Recommendation Report for Planning Permission for Works or Extension to a Dwelling

REF NO: WA/57/20/HH

LOCATION: 8 Prime Close
Walberton
BN18 0PL

PROPOSAL: Extension to roof and loft conversion

Scale Legend

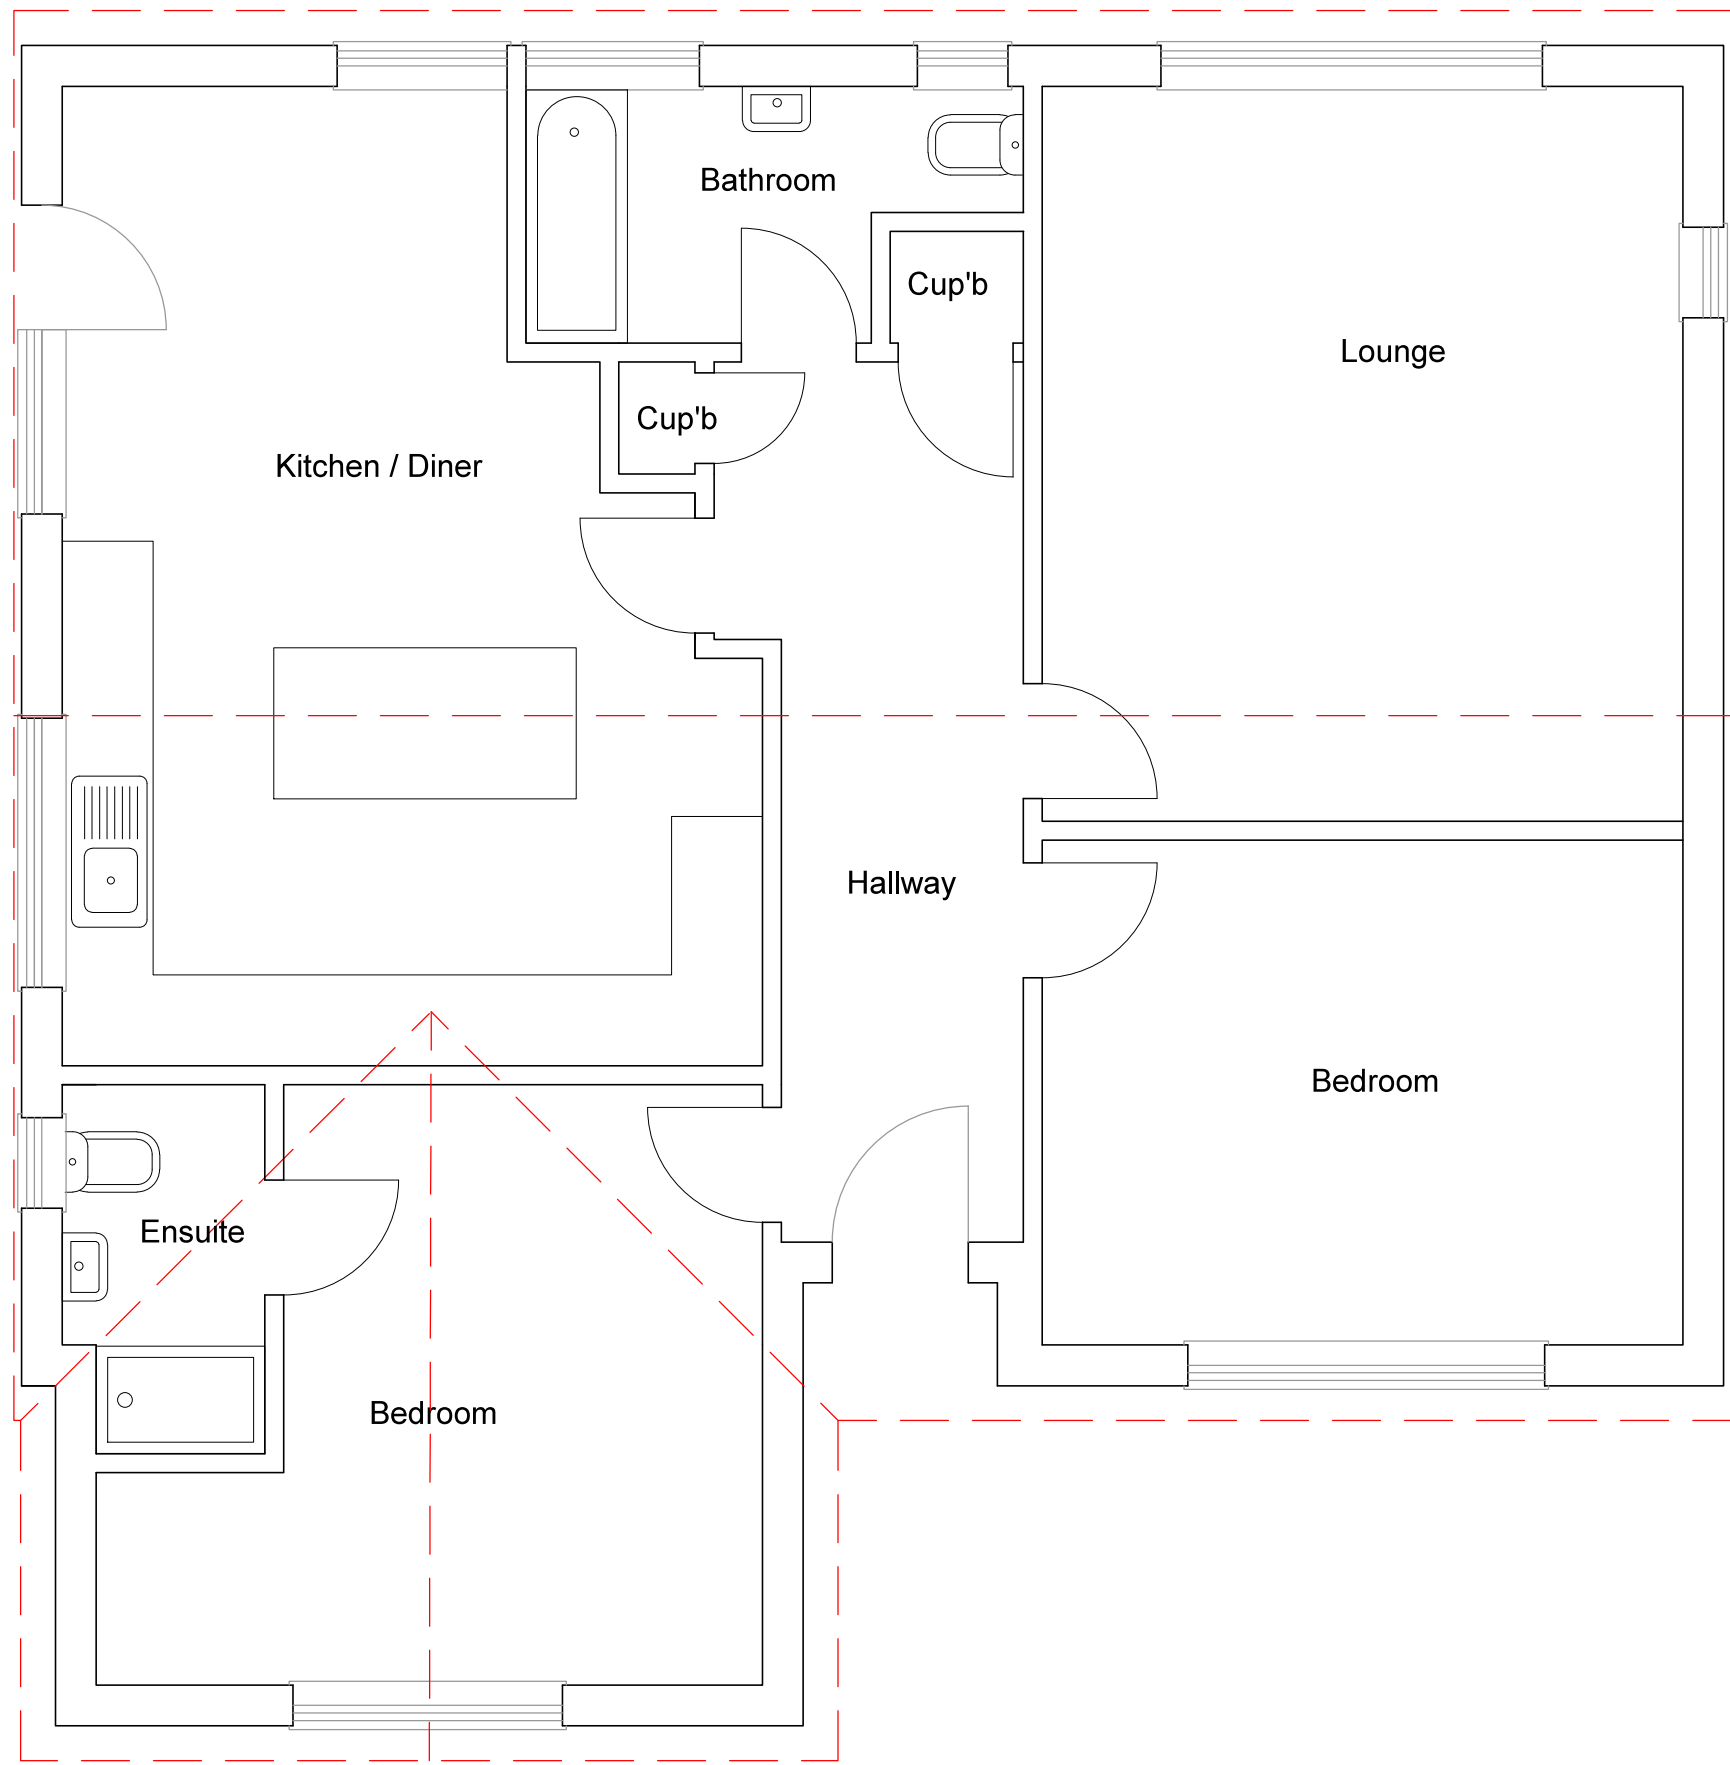
DESCRIPTION OF APPLICATION The application seeks to convert the roof space to habitable space, by way of the construction of a rear dormer extension, and the insertion of rooflights. Initially the application proposed a front dormer, however, this was changed to front Velux windows following negotiation.

- Roof Extension - Floor Plan - PL CC 0102/2020 - Rev. A - 02/11/2020
- Roof Extension - Elevations - PL CC 01/01/2020 - Rev. A - 02/11/2020
